Application Ref:	3/2021/0426	 Ribble Valley Borough Council www.ribblevalley.gov.uk	
Date Inspected:	12 th May 2021		
Officer:	LE		
DELEGATED ITEM FILE REPORT:		Decision	APPROVE

Development Description:	Demolition of an outhouse due to damage from overgrown ivy.
Site Address/Location:	Irwell Cottage 3 Irwell Street Longridge PR3 3NA

3 Irwell Street

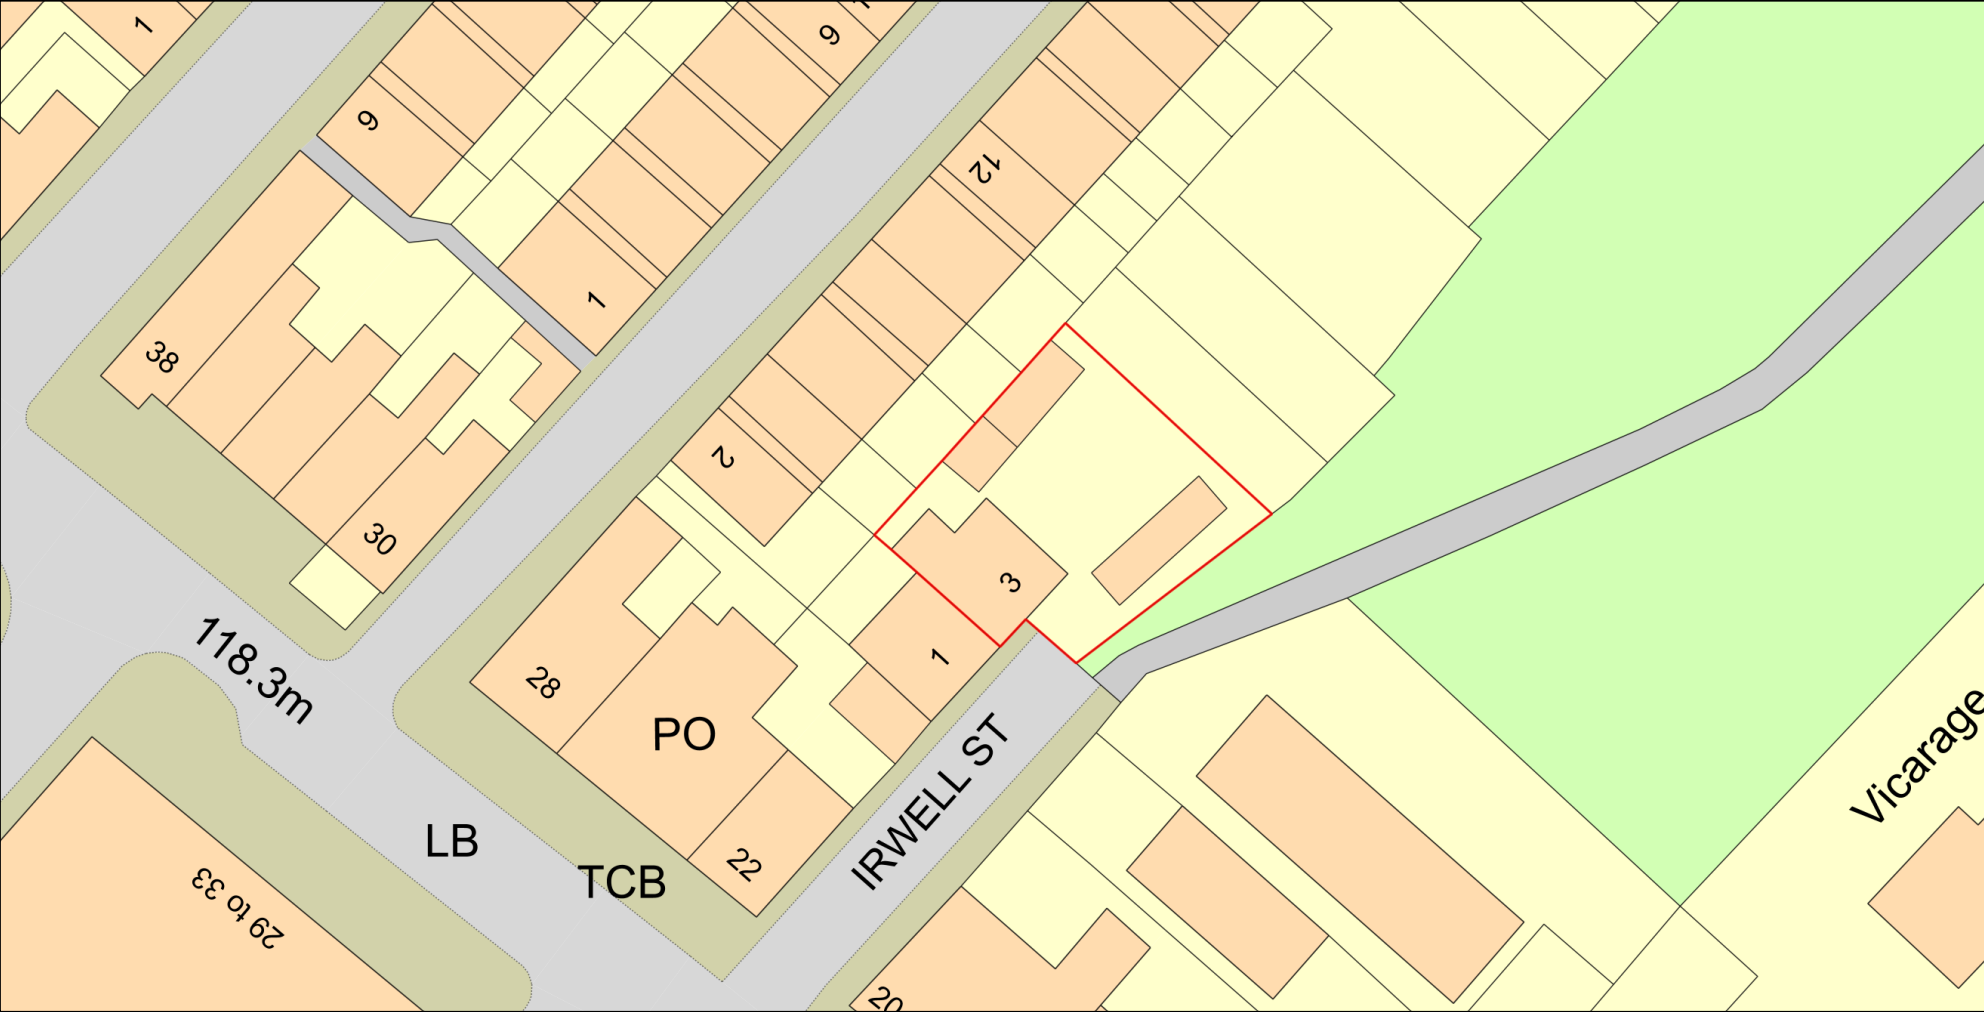
CONSULTATIONS:	Highways/Water Authority/Other Bodies
RVBC Conservation:	
The application does not contain an assessment of heritage significance or justification for demolition (and not repair). The latter is required if demolition would be harmful to the character or appearance of the conservation area (NPPF 194).	
CONSULTATIONS:	Additional Representations.
One representation has been received from a neighbour seeking clarity on the location of the outbuilding to be demolished and whether boundary treatments will be restored.

They have confirmed that they will make the boundary wall good following demolition which will retain the boundary treatments to the rear of Mersey Street.
